Merle Ash  
Land Technologies, Inc.  
18820 3<sup>rd</sup> Avnue NE  
Arlington, WA 98223

Re: 163 RV – *Technical Review 1*  
PA 23016

After preliminary review of the above referenced proposal, the following comments have been prepared:

Horton 453 Type I Ford E - Series Ambulance

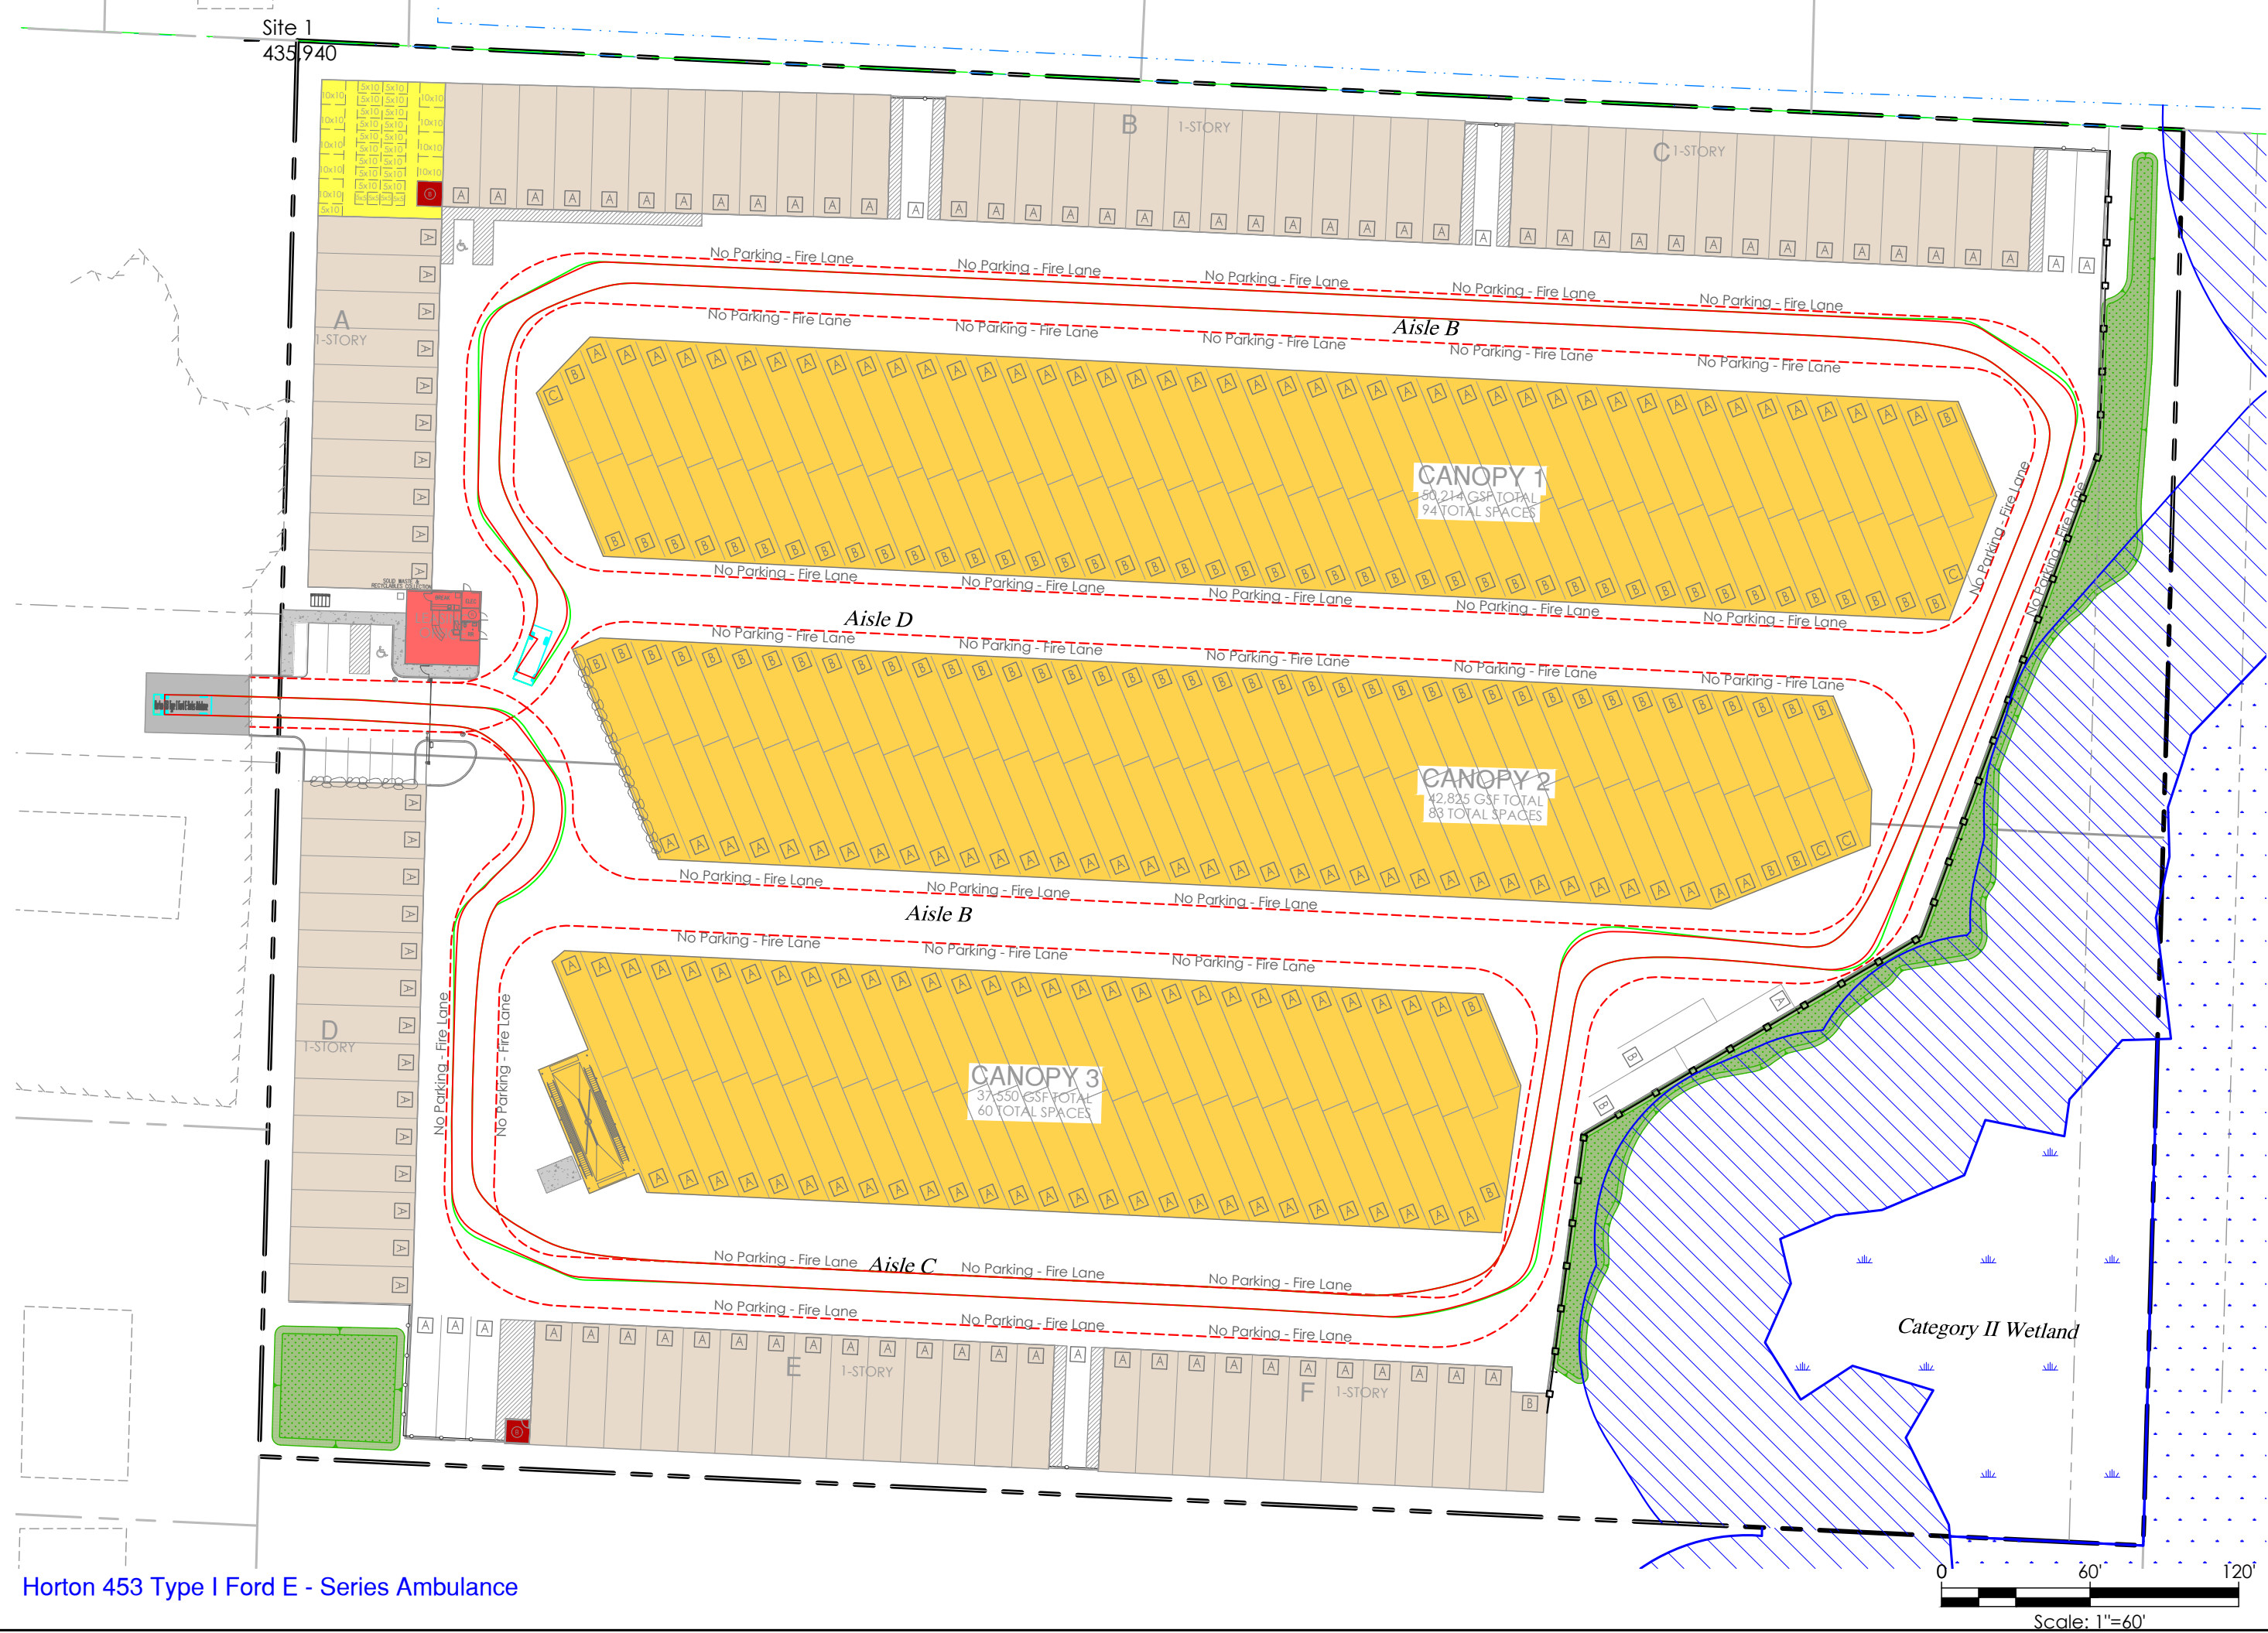
- g. Provide an auto-turn exhibit demonstrating the Emergency Service vehicles, RV's, trucks and trailers can navigate through the site.
7. The landscape plan shall be amended, as follows:
